Diane Sarkies - OBJECTIONS TO CHERRYBROOK STATION

Submission to Application number SSI-5414

RE: Submission to Object application number (SSI-5414)

Figure 7.6 Cherrybrook Station Site Layout

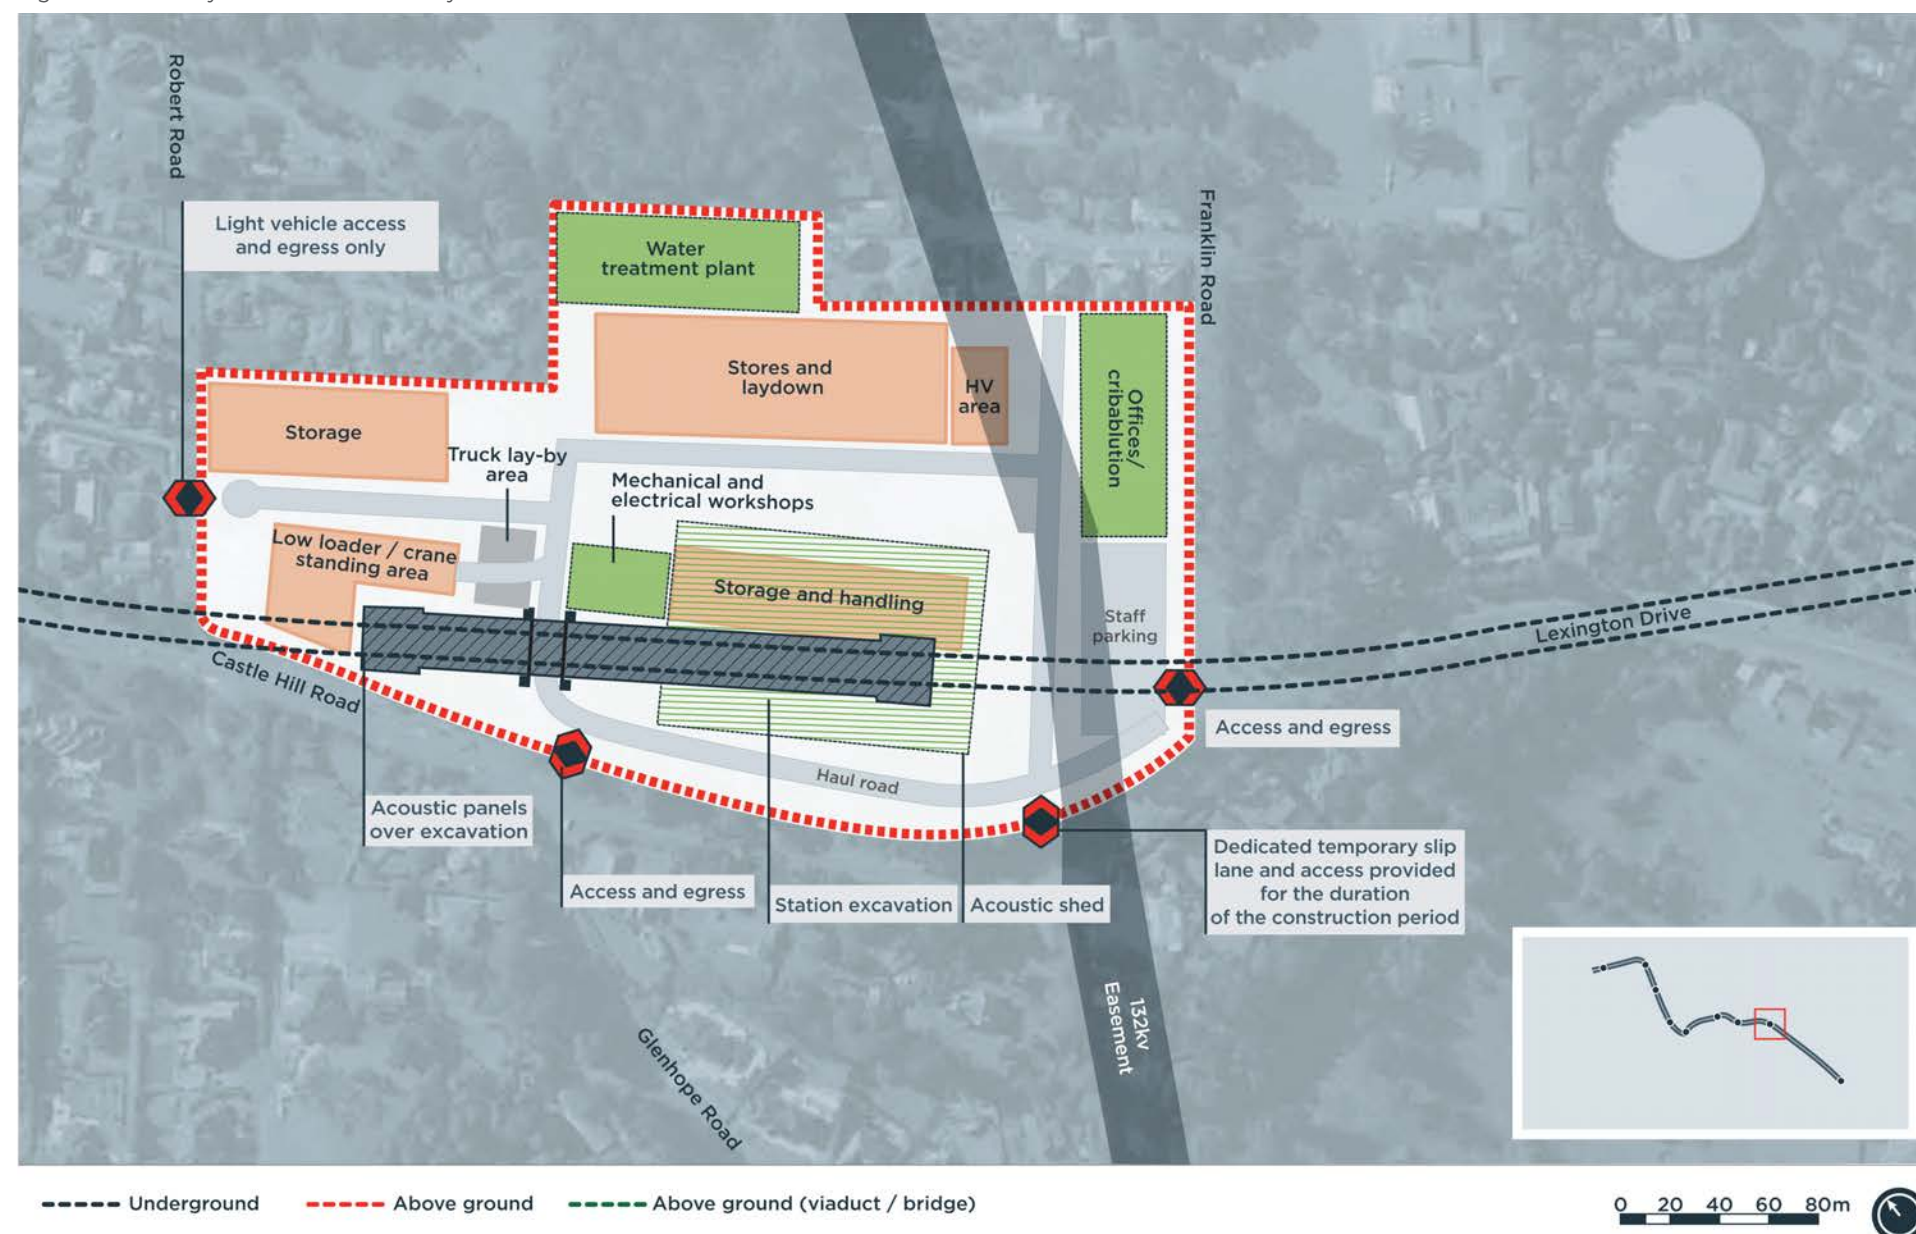
In order to make a clear assessment of how this construction will affect my property I would need a better indication of where the facilities are to be placed, All literature only indicates a proposed layout which has changed several times.

The location of our home is under threat with the proposal to construct right next to Oliver Way,

The residents of Oliver Way need assurance that the designated parking as detailed on the NWRL footprint plan and opposite houses numbers 1 through to number 7 on Robert Road will be maintained only for surface parking. This area contains the protected aforementioned Sydney Blue Gum trees

Figure 10.10 Cherrybrook Station Construction Site and Receiver Areas

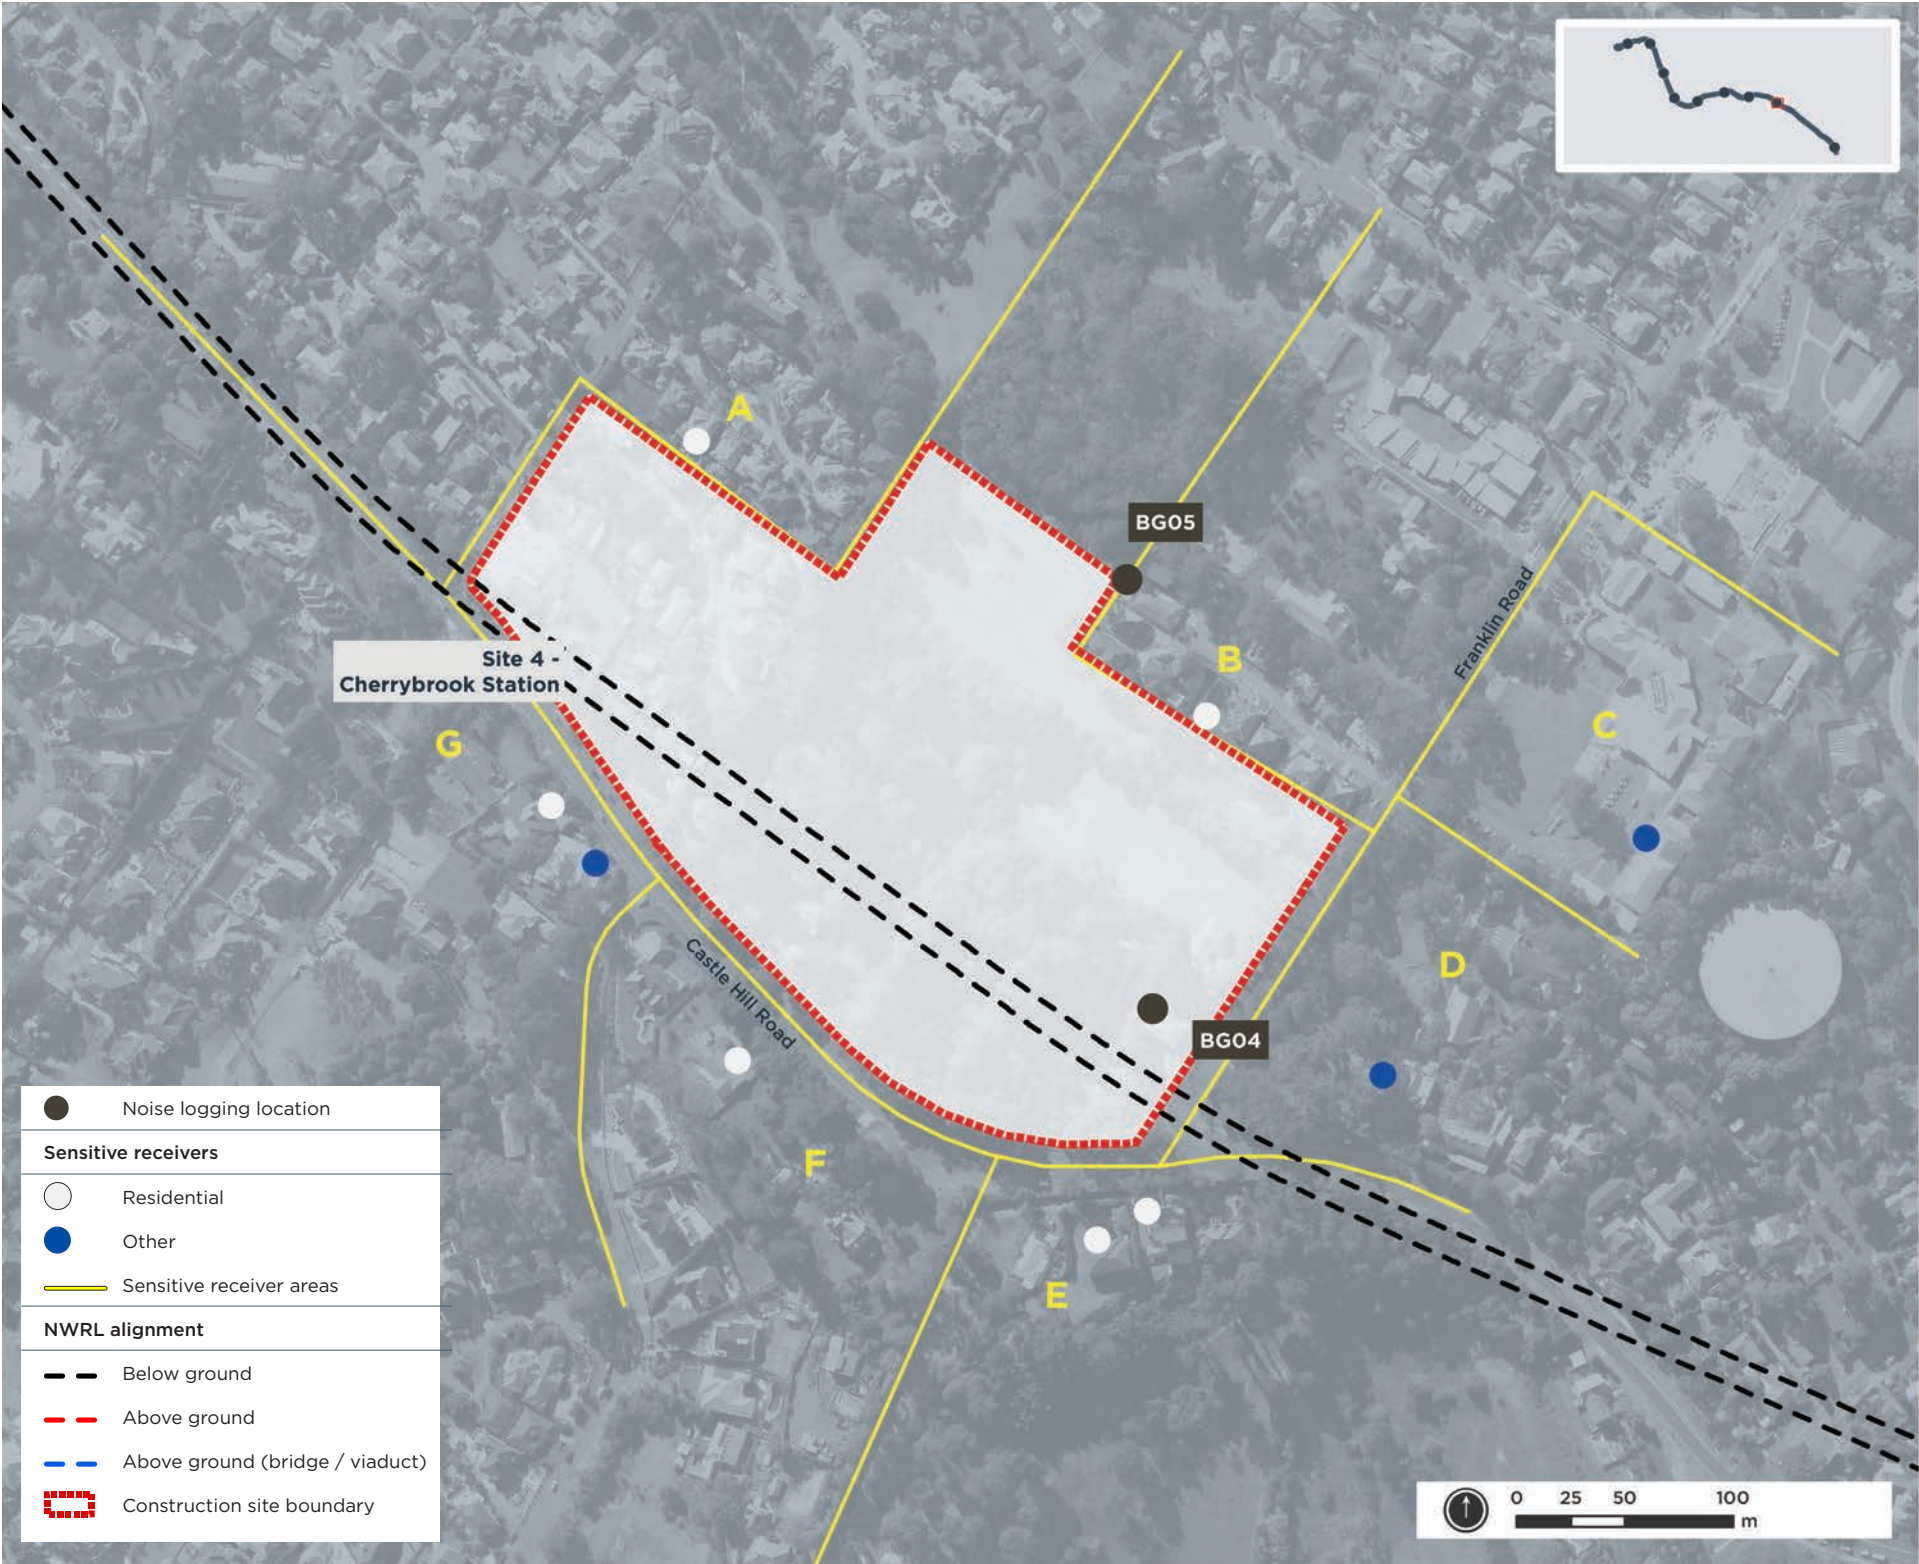
I object to the Noise and Vibration that will be caused by the construction work relating to the Cherrybrook Station. I understand that according to the Environmental Impact Statement a Six meter sound barrier will be constructed to minimise the noise. No documents have been found to indicate where this wall will be built. This is not acceptable. It should also be taken into account that the six meter wall is on the high side of the street and will tower over our homes. My particular property will be looking straight into this proposed wall. The acoustic shed to house the crane is said to be 15m high, where would this be located? I run my business from my home office and most of my work is done via email and telephonic conversation. To say that construction will take place during work hours affects me and will impact on how I am able to operate. I would hope this noise is kept to a minimum level.

The essential need for effective buffer zone/acoustic fencing.

We consider that at a very minimum it is necessary that a buffer zone of at least 20 metres from Oliver Way boundary fences is erected, with rows of trees planted between the boundary fences and high (six meters) acoustic fencing, in such a way as to shield the Oliver Way residents from visual, acoustic, dust, and the inevitable construction issues arising from the construction site.
